CITY OF ALBUQUERQUE

PLANNING DEPARTMENT – Development Review Services

**RE: Morningstar at Palomas
Grading and Drainage Plan with Supplemental Drainage Calculations
Engineer's Stamp Date (9-5-14) File: D19D029**

Date:	No.	Revision:	Date:	Job No.
08-29-14	1	REVISED STAMP DATE PER C.O.A. HYDROLOGY TRACKING	09/10/14	IA:2033
Drawn By:	BUB			CG-102
Chd By:	FCA			SH. OF

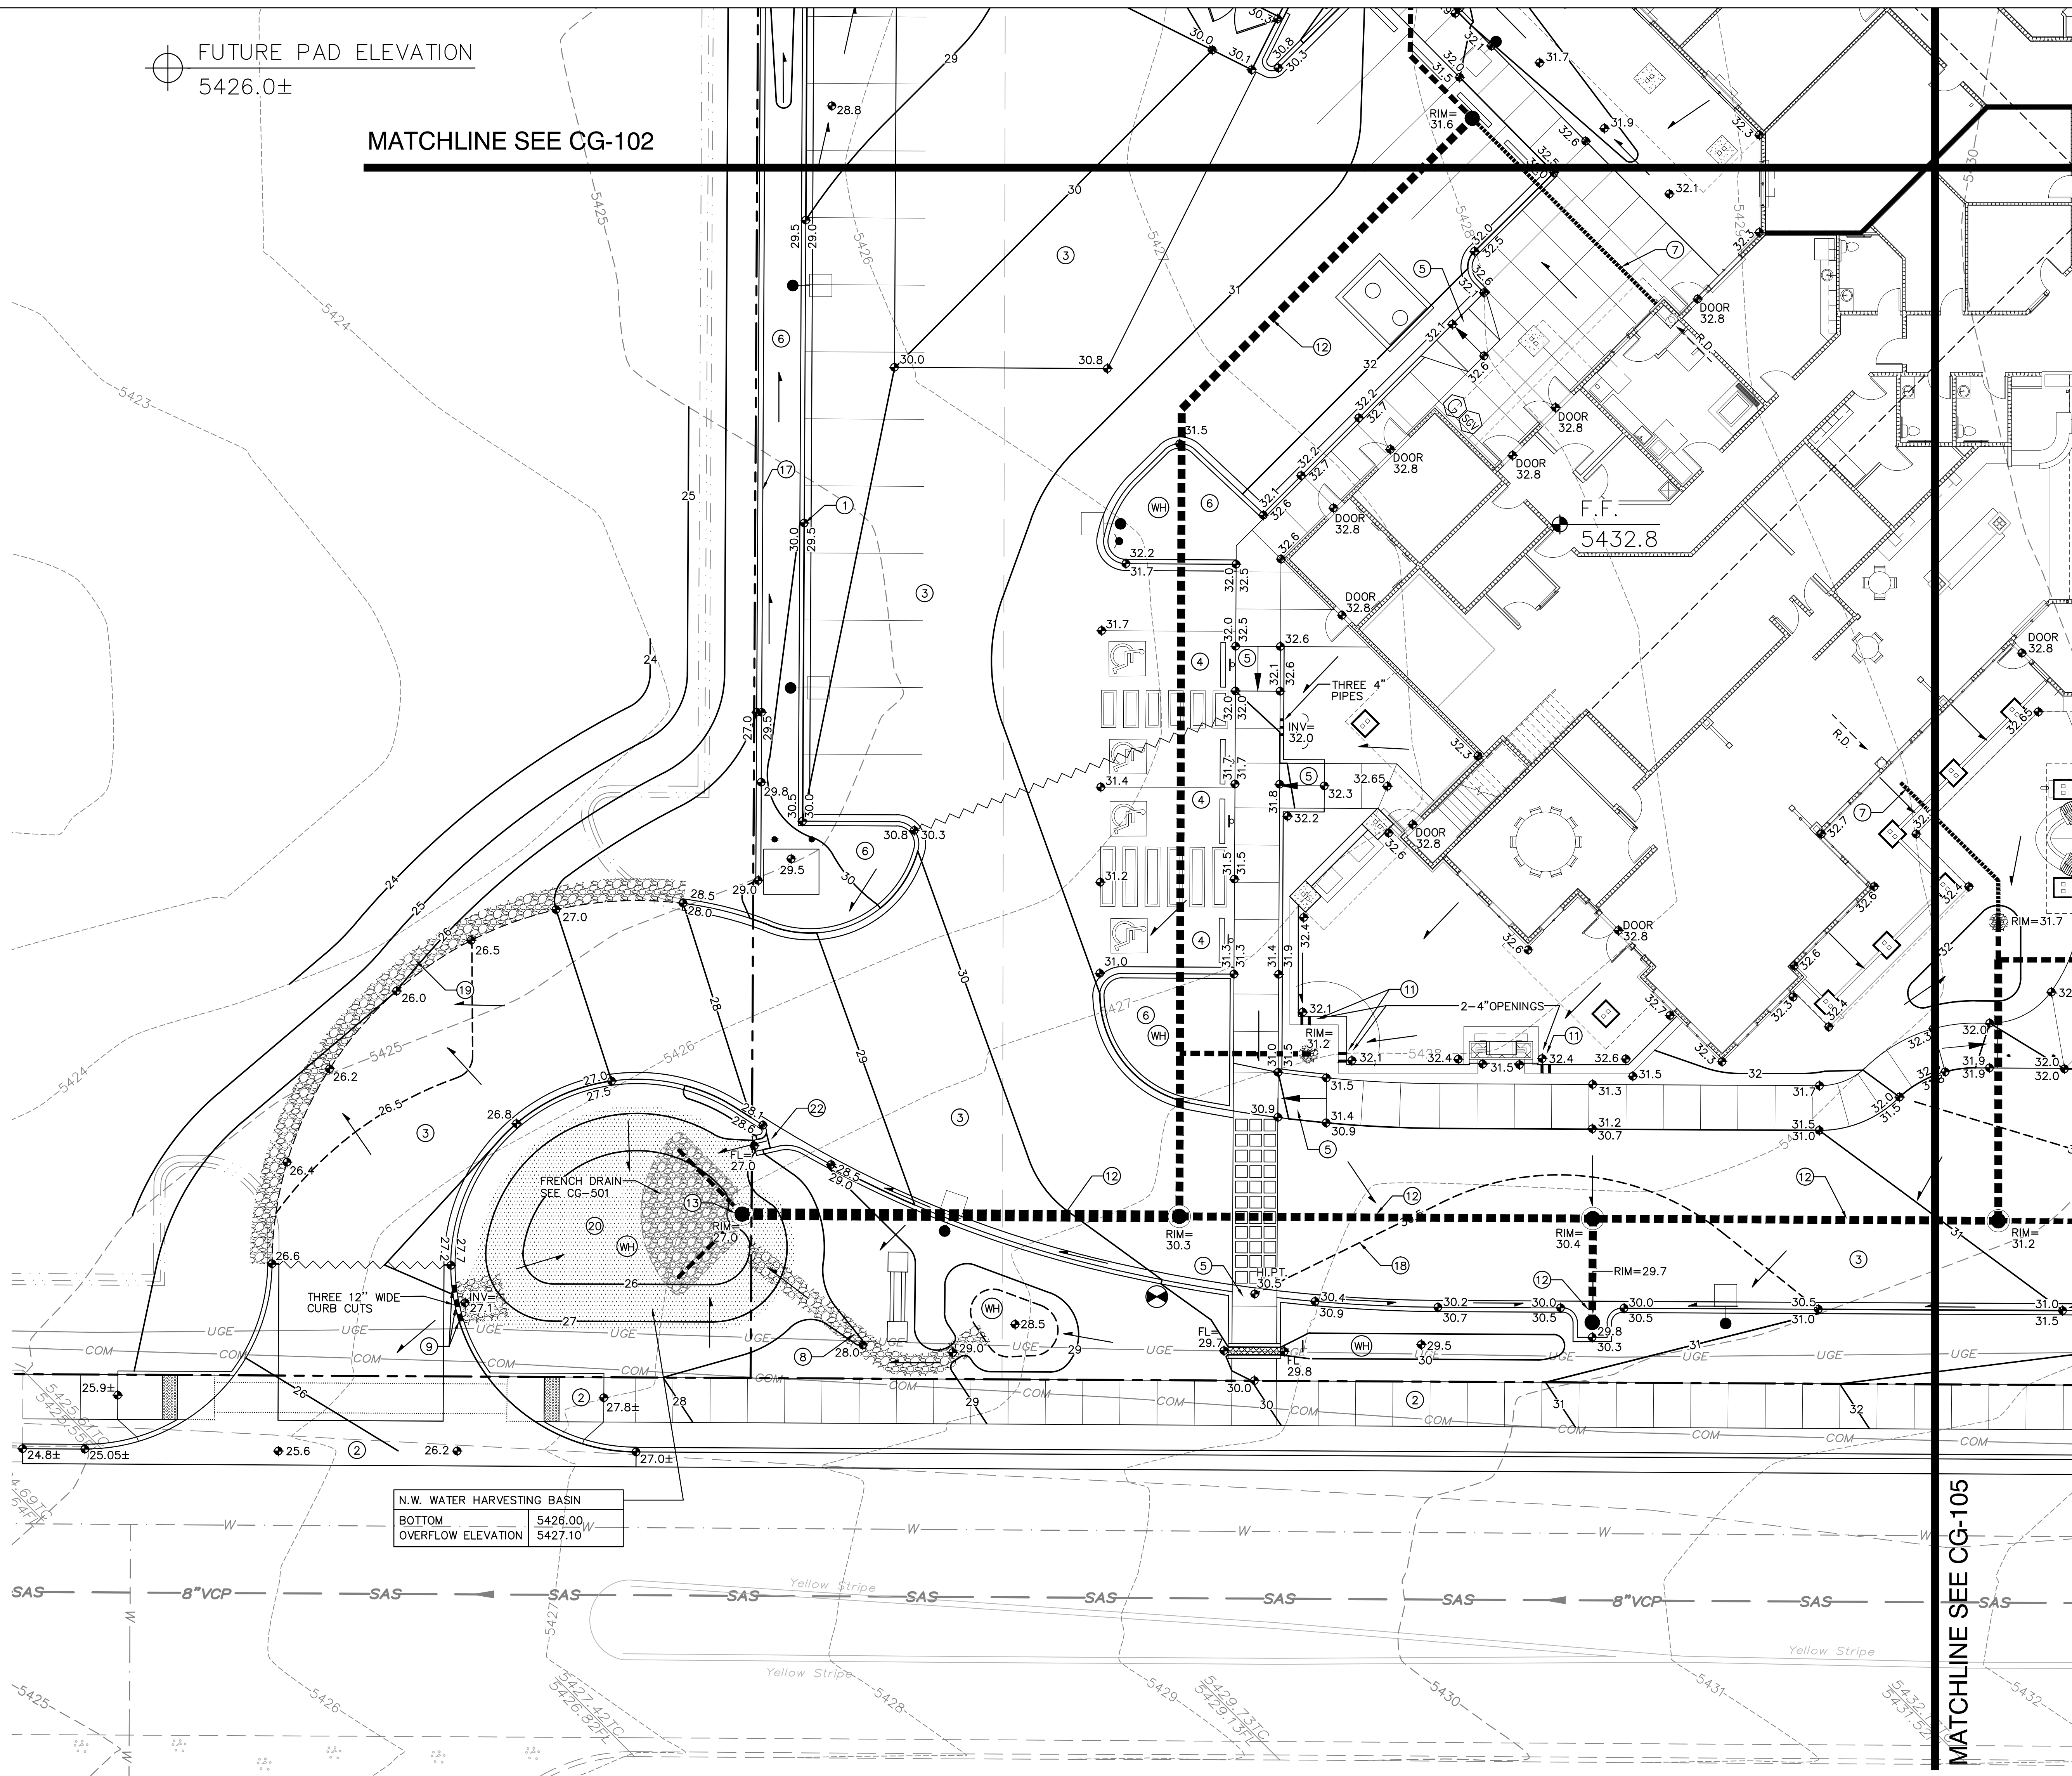
3. Sheet CG-102, at the sidewalk behind the trash enclosure, the grade falls at more than a 2:1 slope (from 32' contour to 30.7 T.O. SW). At end of SW, the grade gets higher right before the water harvest pond. The inlet should be in a sump condition so that runoff does not bypass inlet and flow into Basin 10.

Date:	08-29-14	No. Revision:	1	Revised Stamp Date Per:	09/10/14	Job No.:	IA: 2033
Drawn By:	BUB	C.O.A. Hydrology Tracking:					CG-501
Chk By:	FCA						SH. OF

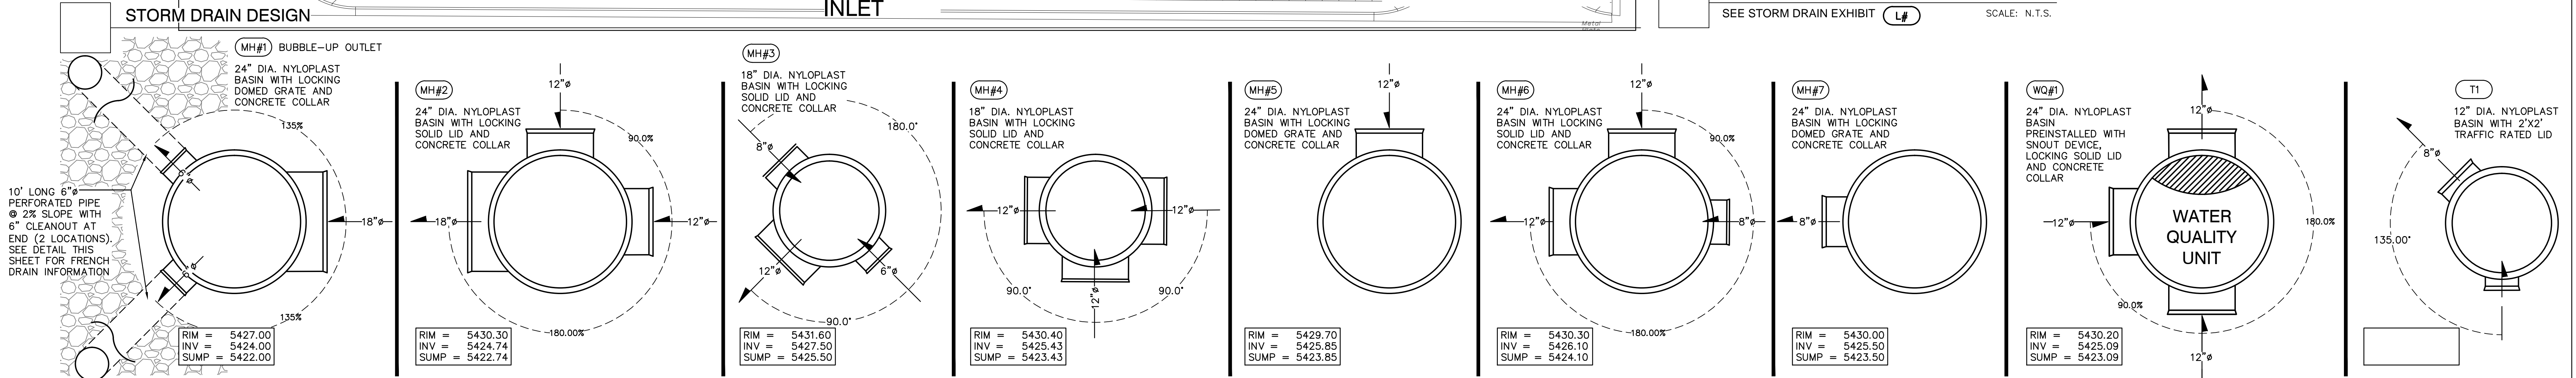
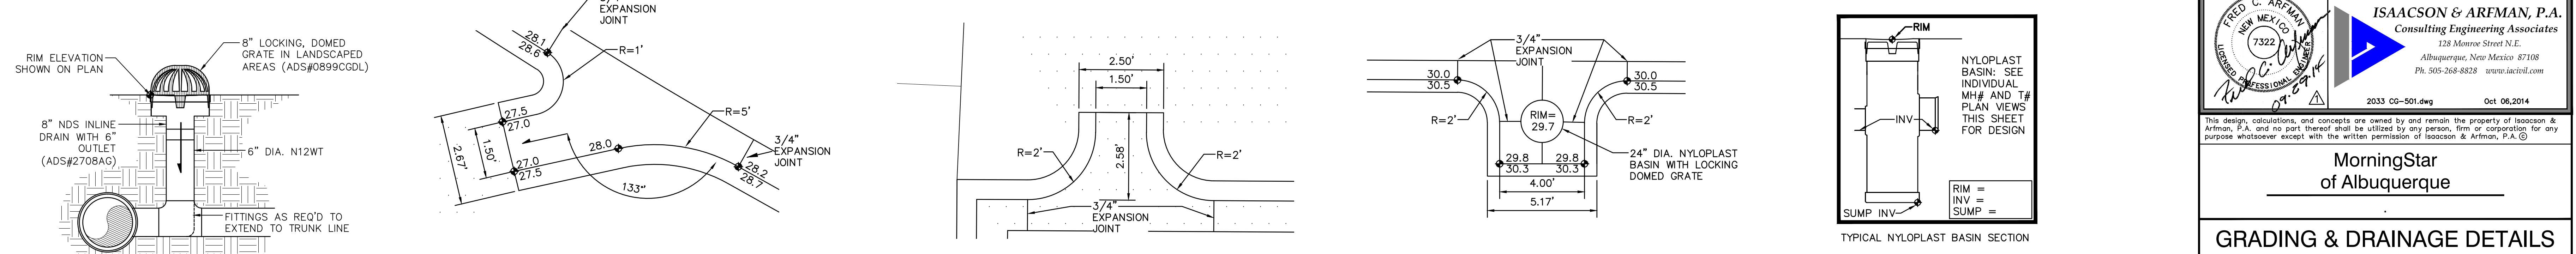
1. Calculations of NE Pond Outlet pipe to Paseo Del Norte use a 4" dia. pipe to restrict flow to 0.7 cfs, using a 3' head (pg.8). However, Plan Sheet CG-501 show a 8" dia. pipe, and the MH#7 detail shows a 12" dia pipe. Also, invert elevation (2425.52) and Pond WSEL elevation (2431') indicate a head of 5.3' should be used instead. Since 4" pipe is already pretty small, and head is already over, how can you meet the 0.7 max. cfs.
